Application ID Number:

JOB	Laughlin Project GVI	
SHEET NO.	_____	OF _____
CALCULATED BY	Leddy Housen	DATE 10/3/02
CHECKED BY	_____	DATE _____
SCALE	1" = 1'

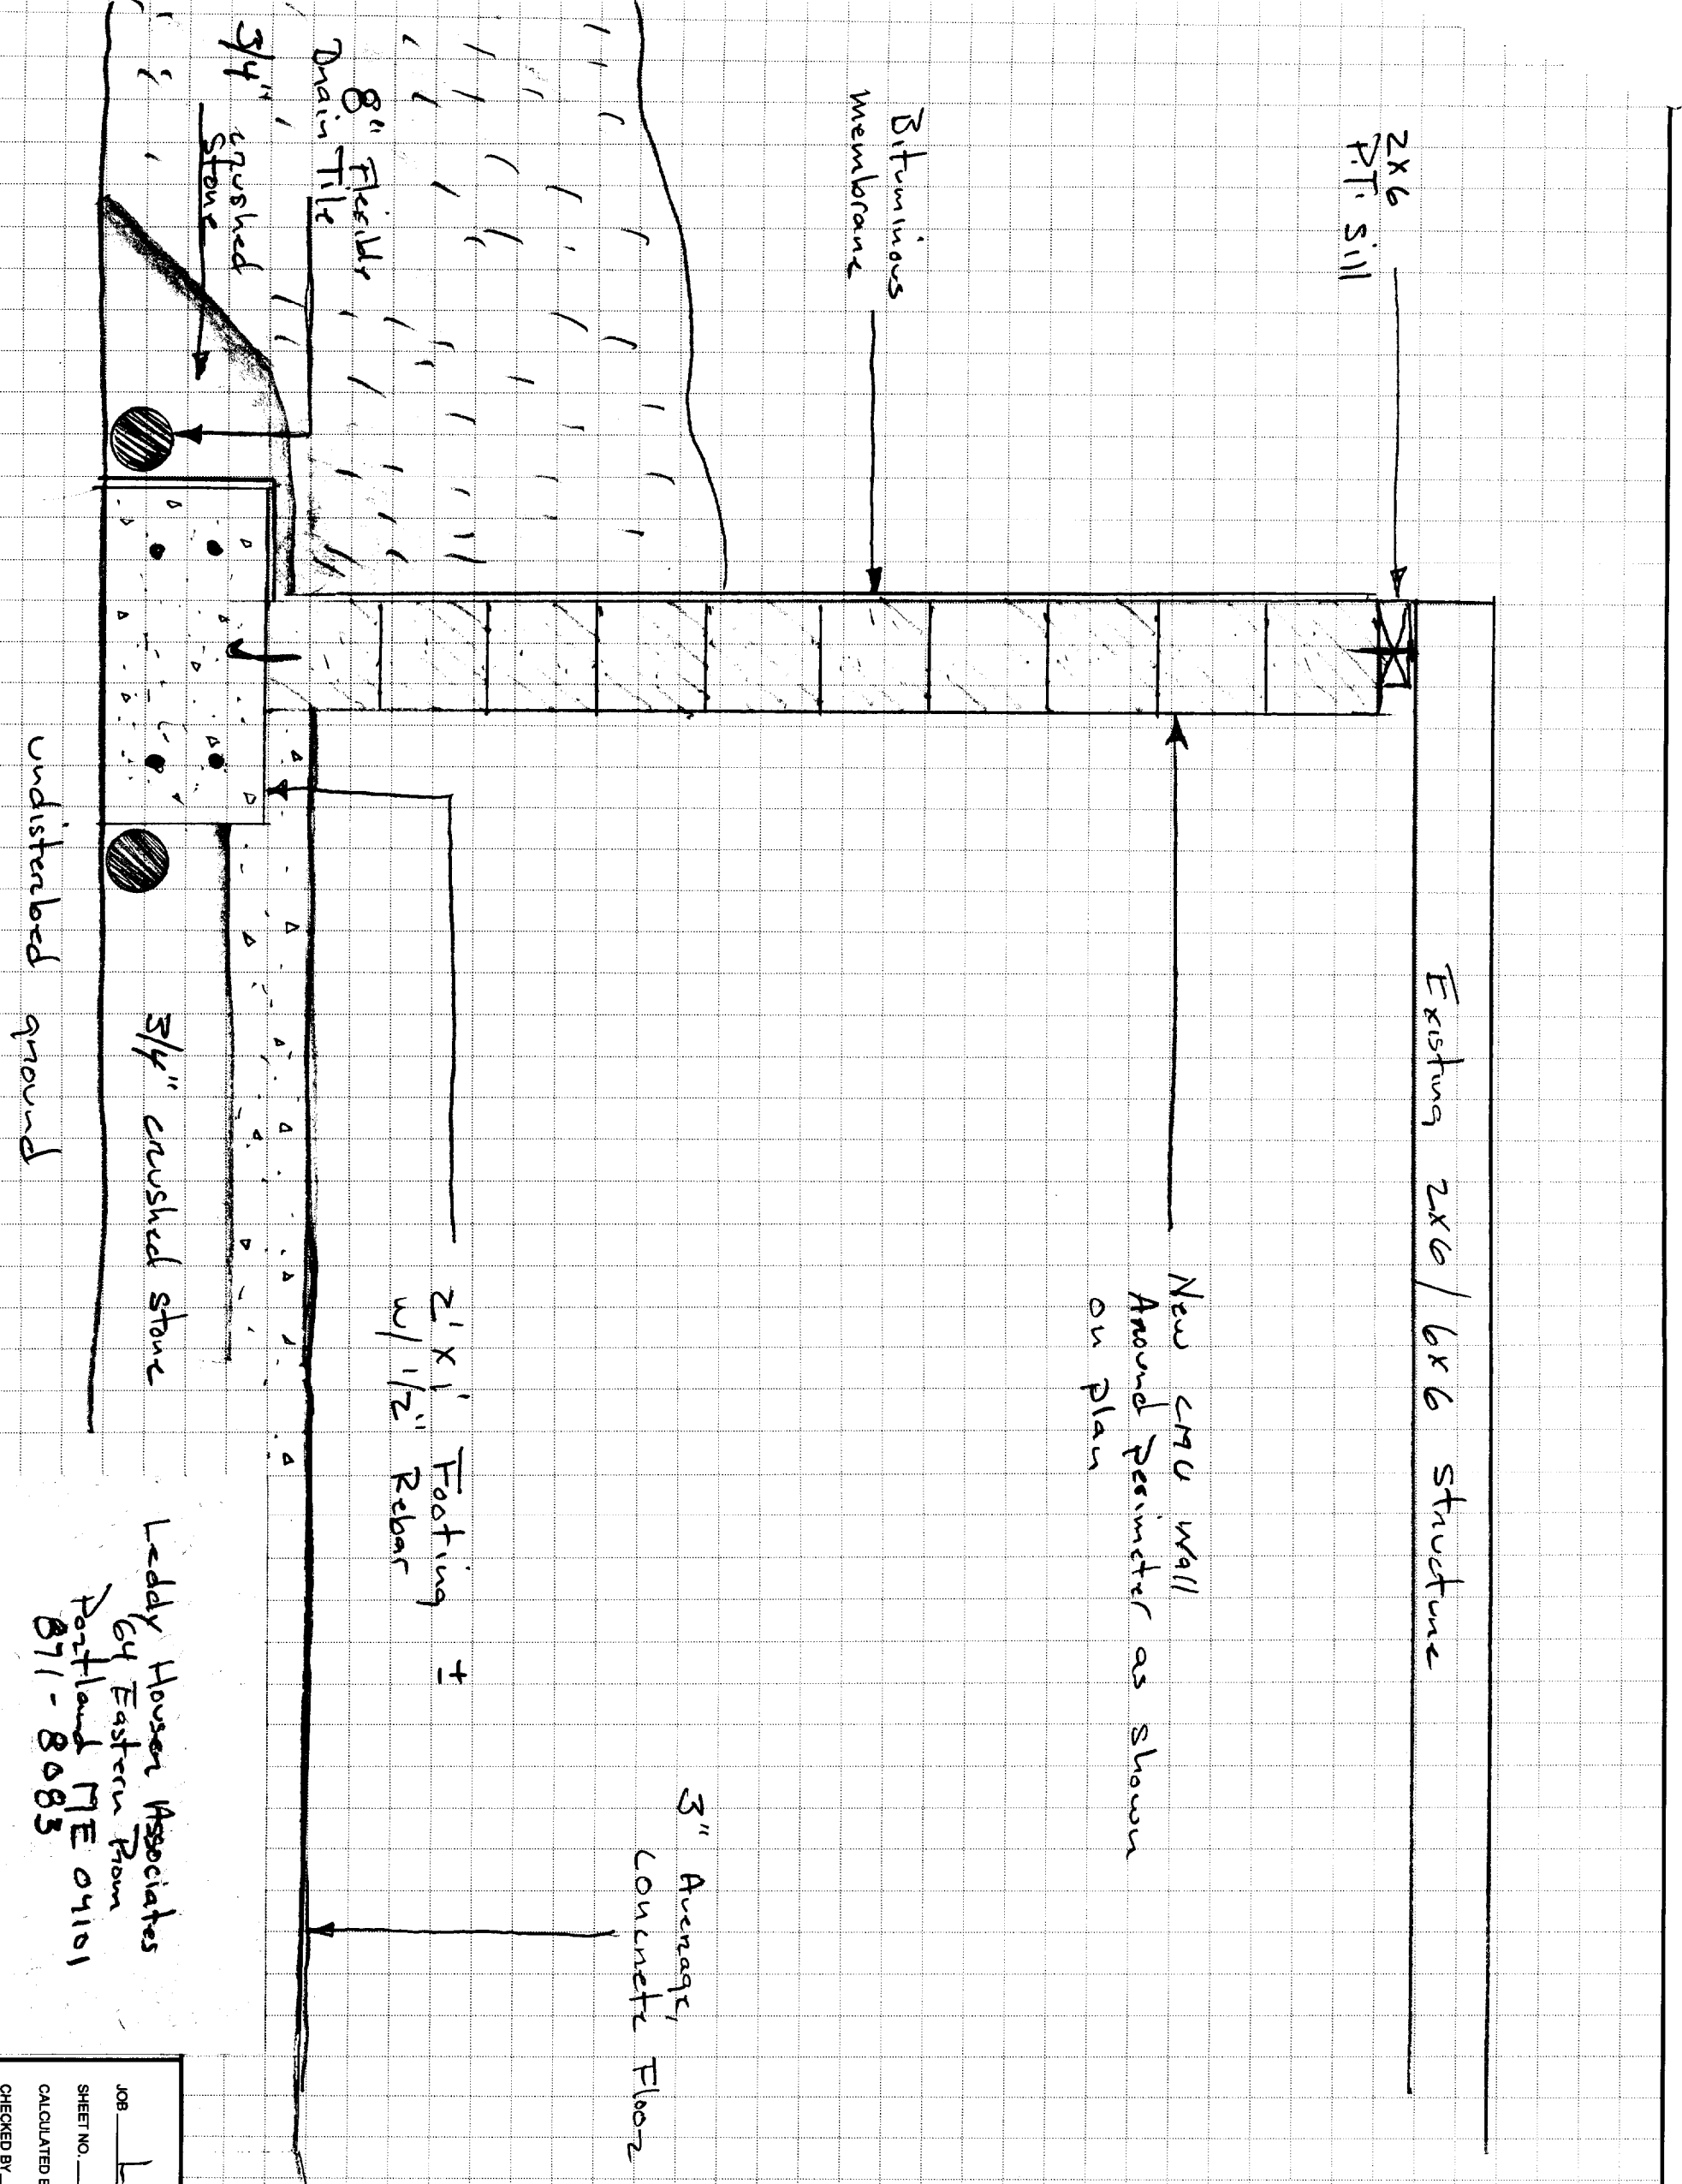
Sonor tube locations for deck support to be field determined and Ok'd prior to placement. All CMU to be reinforce with horizontal (dura-wall type) and vertical re bar.

Lally columns to be set 7' on center
